City of Ryde Submission

North Ryde Station Precinct – Modification 6 SSD-5093-Mod-6

Modification of North Ryde Station Precinct SSD-5093 - Increase GFA, modify building layout, open space, roads.

Submission Date: 26 September 2023

Figure 01. Land application map

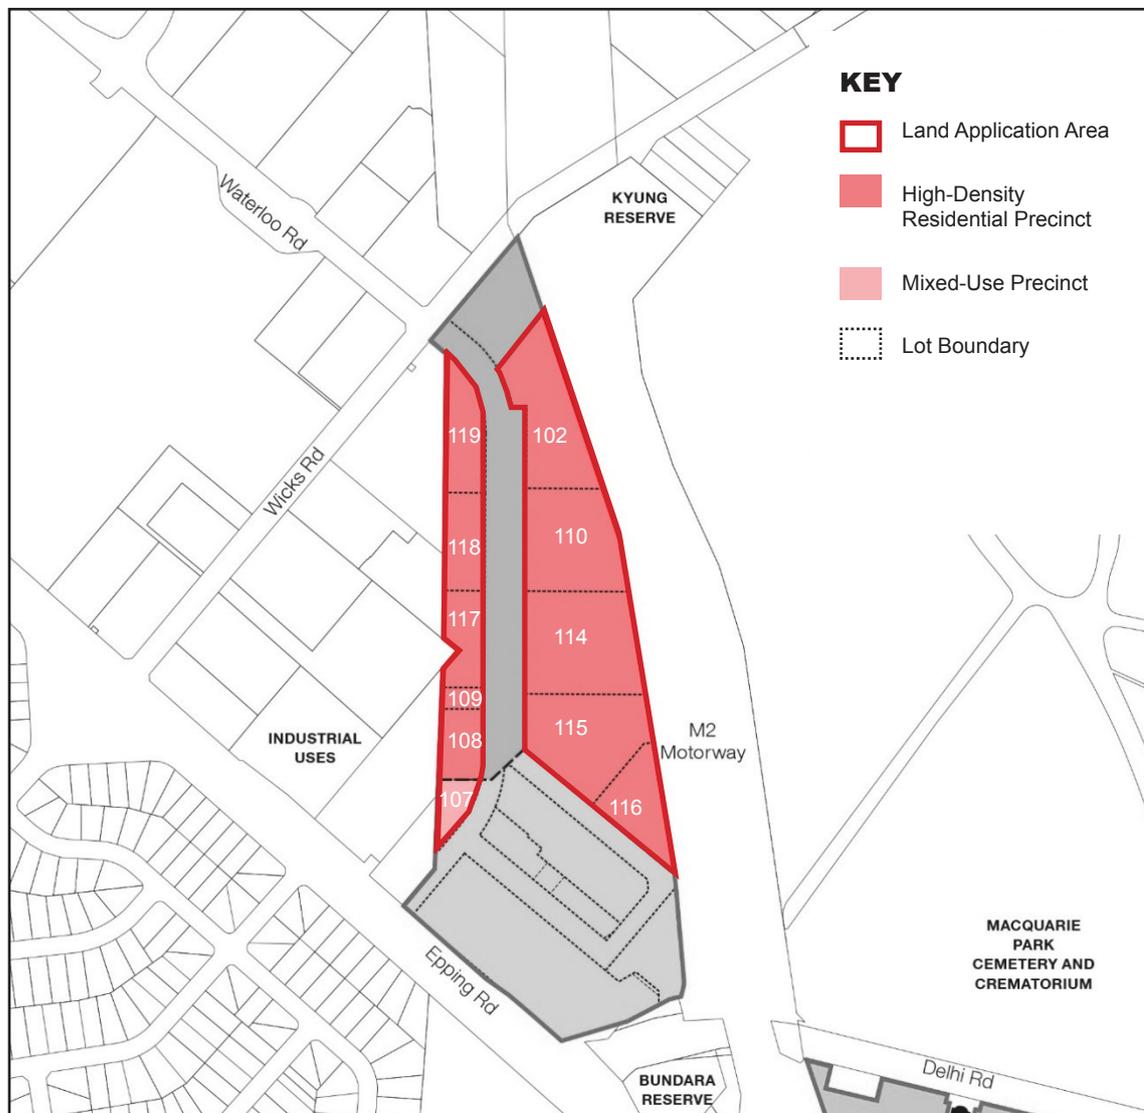
Notwithstanding the above, the Applicant's approach of only applying their guidelines to half of the entire residential precinct (Figure 4), is inappropriate and does not deliver a cohesive vision for the precinct and could result in a vastly different urban design outcome as two different urban design guidelines would apply to either end of the precinct (if approved). The Applicant's approach is not supported by Council, particularly as Council has a prepared detailed design guideline that applies to the **entire** Residential Precinct under SSD-5093 known as the "*Urban Design Guidelines for High-Density Residential Precinct & Lot 107 Lachlan's Line*" (LLUDGL). These Guidelines will be attached under separate cover (**Attachment 2**).

Rather than seek to exclude applicability of the LLUDGL from the Applicant's land, Council would request that the Applicant, in-conjunction with Council, propose amendments to the LLUDGL, with final approval from Council and then have them formally apply to SSD-5093, via an amendment to condition E2.
